REPORT UPDATE

Application No: AL/35/26/RES

LOCATION: Land rear of Meadow Way
Westergate

PROPOSAL: Approval of reserved matters following outline consent AL/178/22/OUT for appearance, landscaping, layout and scale for the construction of 89 No. residential dwellings, together with open space, landscaping and associated infrastructure, with access taken from Meadow Way (resubmission following AL/137/24/RES). This application is in CIL Zone 3 and is CIL Liable as new dwellings.

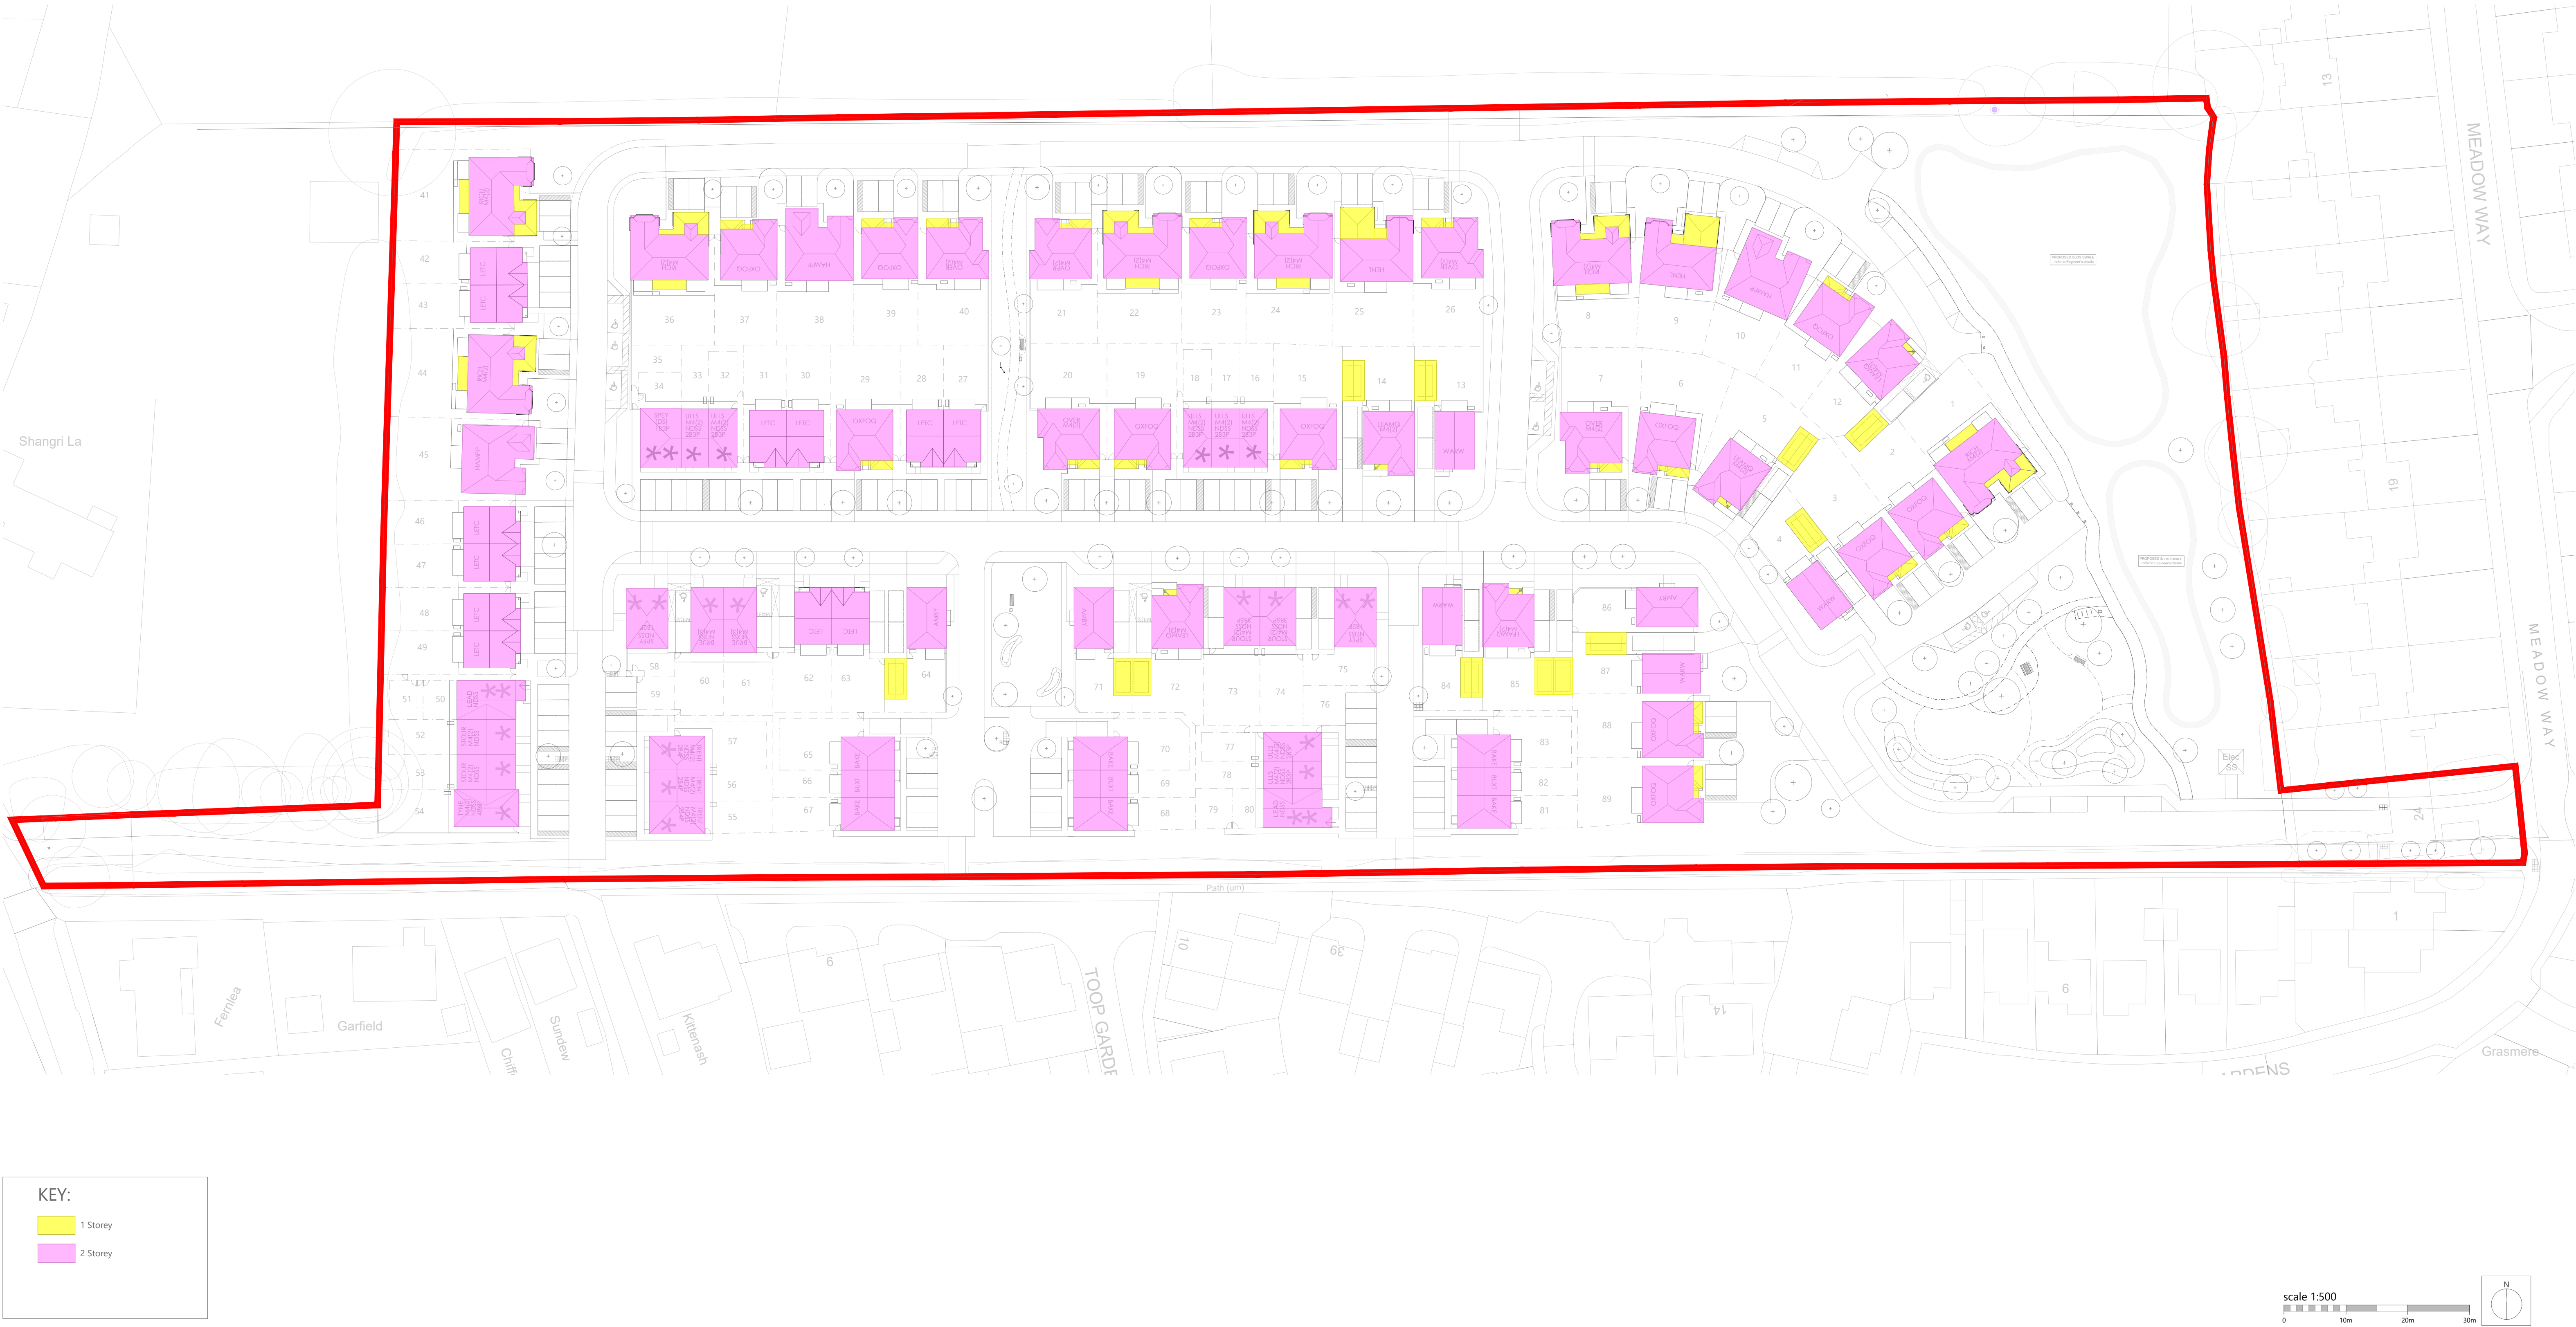
The flatted three storey building in previous applications has been removed and replaced with two storey dwellings which is positive, with three storey development out of keeping with the wider area.
